Rezoning Transportation Analysis

Petition Number: #2022-084

| Date | Description |
|----------|--------------------|
| 12-15-22 | Second Review (DR) |

**SCHEMATIC**  
**SITE PLAN**

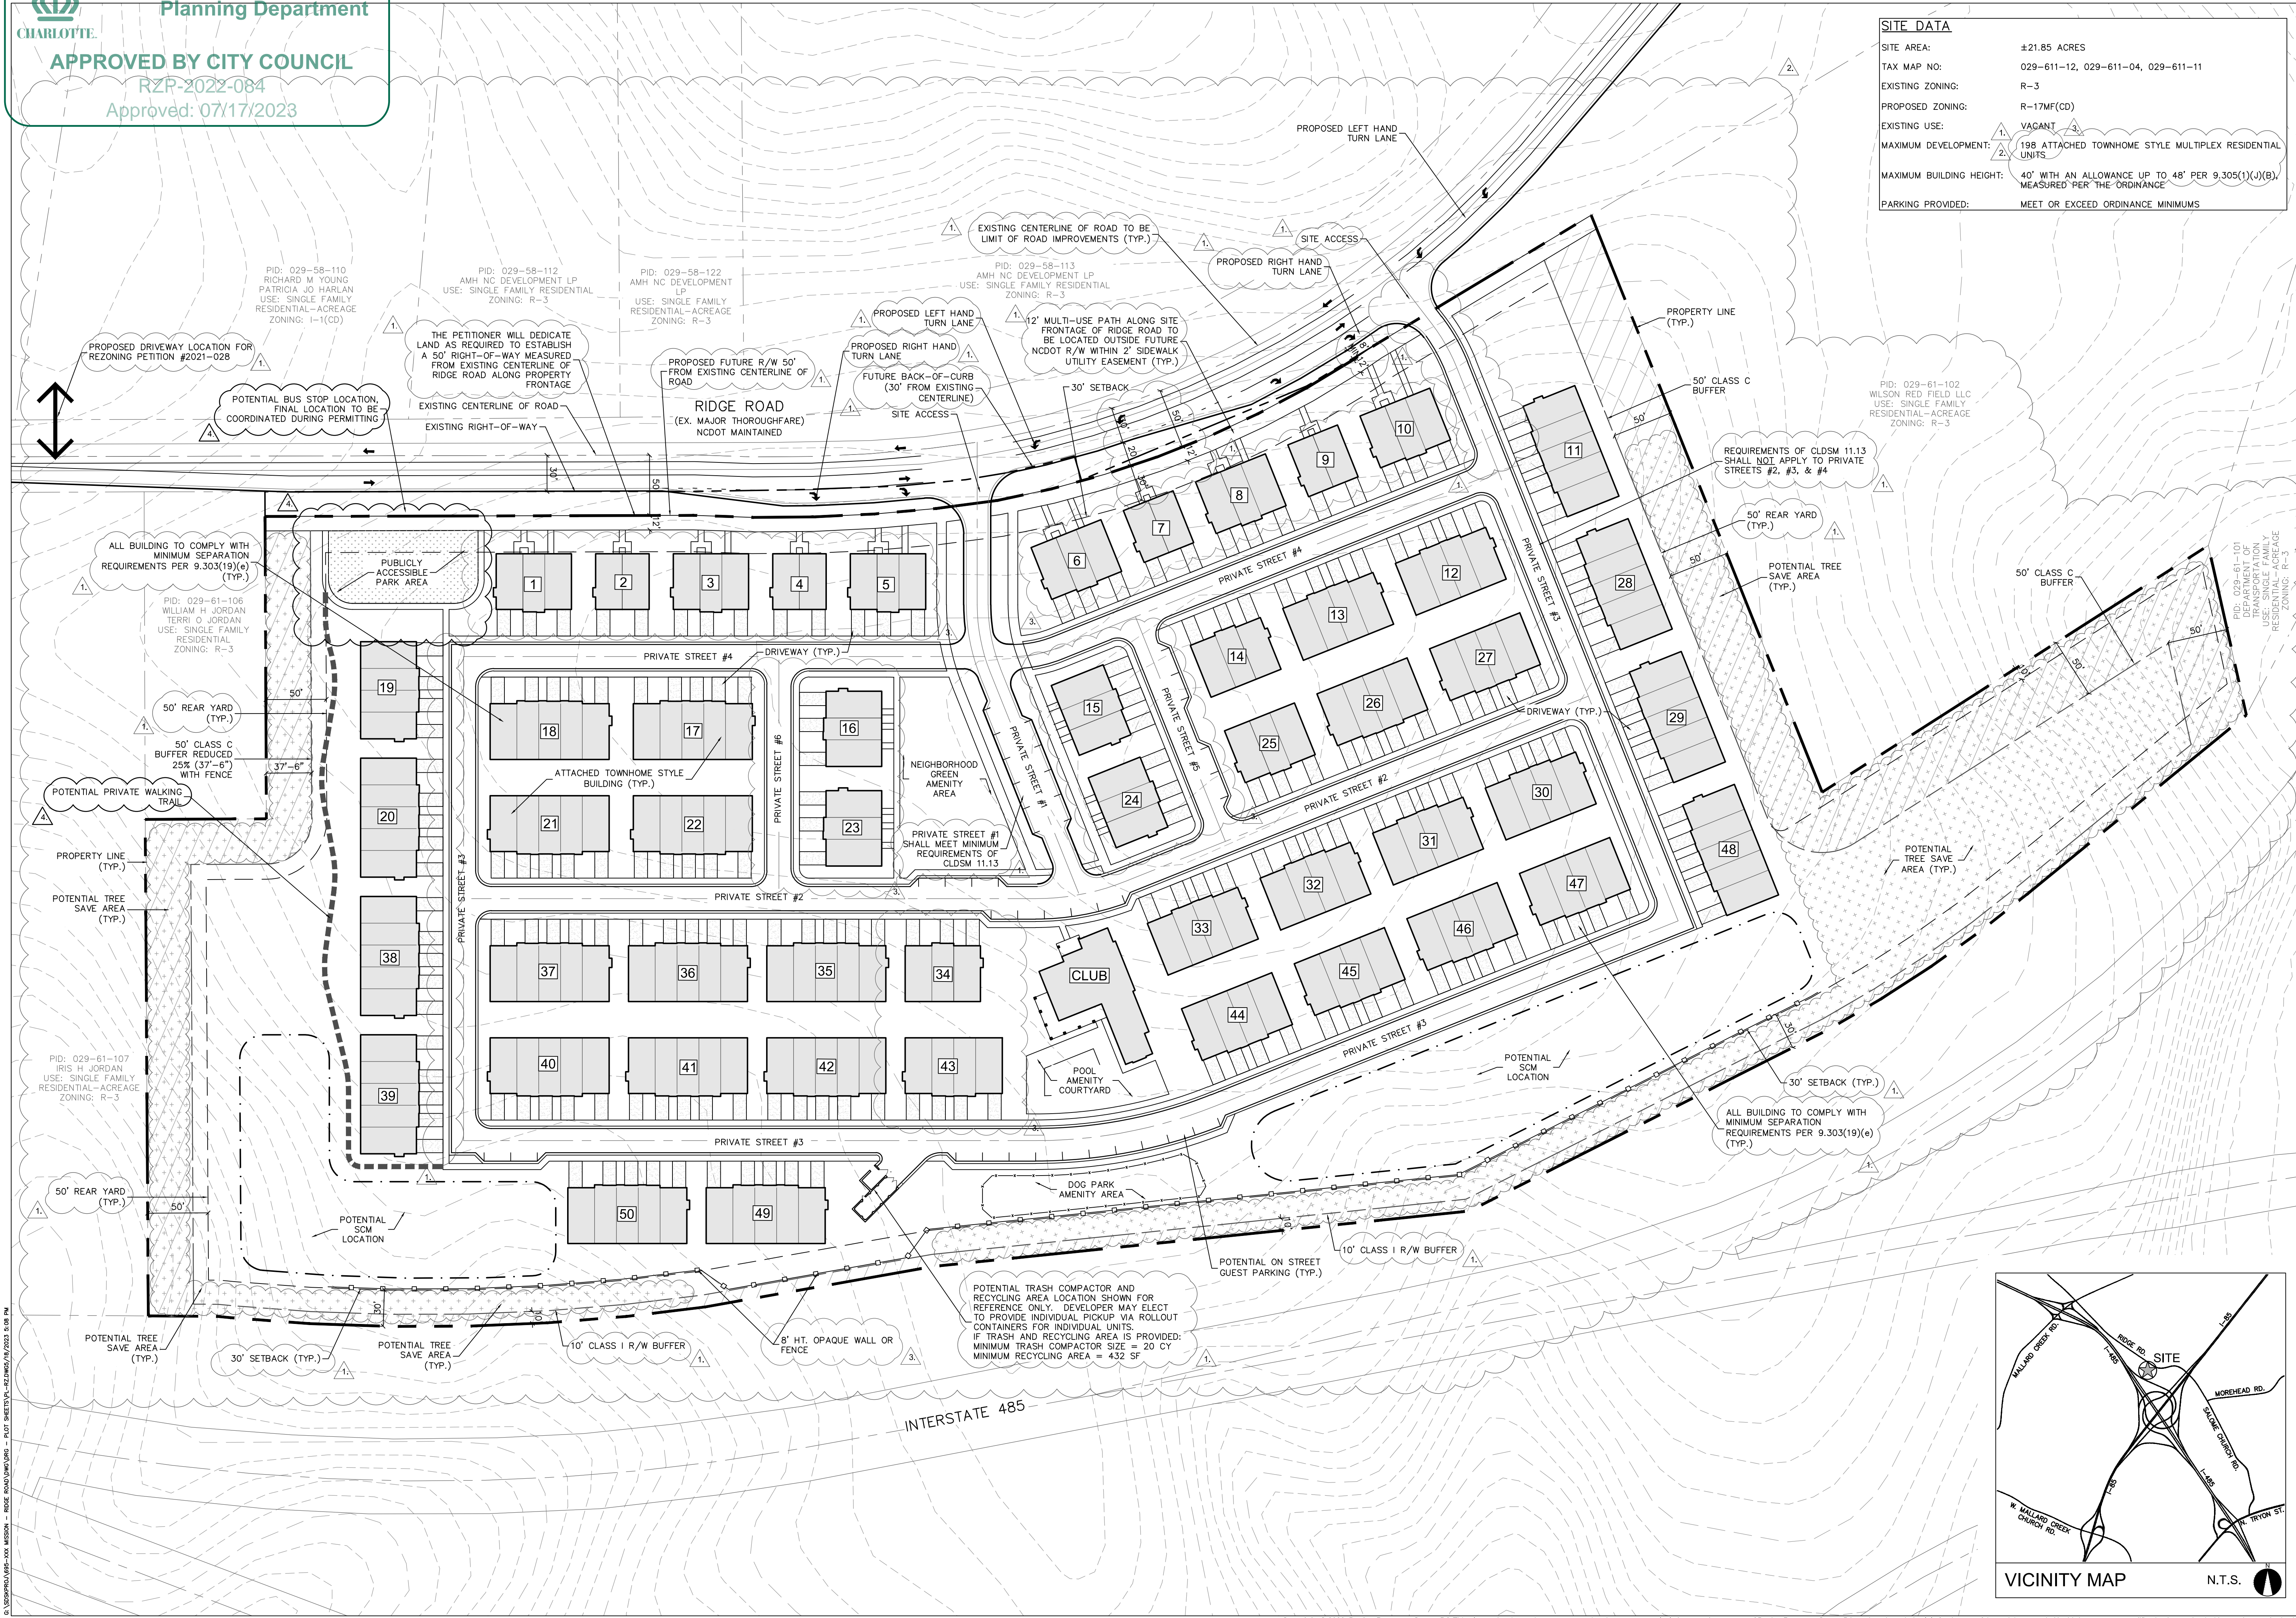
- ~~**Curbline:** The proposed zoning district has a setback measured from back of the existing or proposed future curbline.~~
 - ~~**Ridge Road:** The future location of curb and gutter is measured at 30 feet from the centerline of the roadway to the BOC.~~

~~Label and dimension the curb and gutter from the centerline for each road on the site plan.~~

- ~~Revise site plan and conditional note(s) to commit to dedicate 50 feet of right-of-way from the road centerline. The site plan shall label and dimension the right-of-way from the road centerline.~~
- ~~Site plan and conditional note(s) revisions are needed to commit to constructing internal private roads to meet or exceed CLDSM standard 11.13. Site plan shall callout CLDSM 11.13 and add roadway cross section detail.~~

5. ~~Site plan and conditional note(s) revisions are needed to commit to constructing a full three lane section on Ridge Road along the site frontage. 3 lane section to include a two-way left turn lane along the site frontage and two through lanes. Dimension the transition length and width of the two-way left turn lane along Ridge Road per NCDOT comments.~~

6. ~~Site plan and conditional note(s) revisions are needed to commit to constructing a right turn at both driveways per NCDOT comments.~~
7. ~~Site plan and conditional note(s) revisions are needed to commit to aligning site entrances with the Kings Grant rezoning (2021-028). Site plan shall show linework from Kings Grant development along Ridge Road. **Comment Rescinded 12-22-22**~~

11. ~~Revise site plan to construct a 12-foot multi-use path on Ridge Road. The site plan shall label and dimension both items from the back of curb and gutter and road centerline. The entire facility must be outside of the right of way and within a public access easement. Add conditional note committing to construction and maintenance of the 12-foot multi-use path on Ridge Road.~~
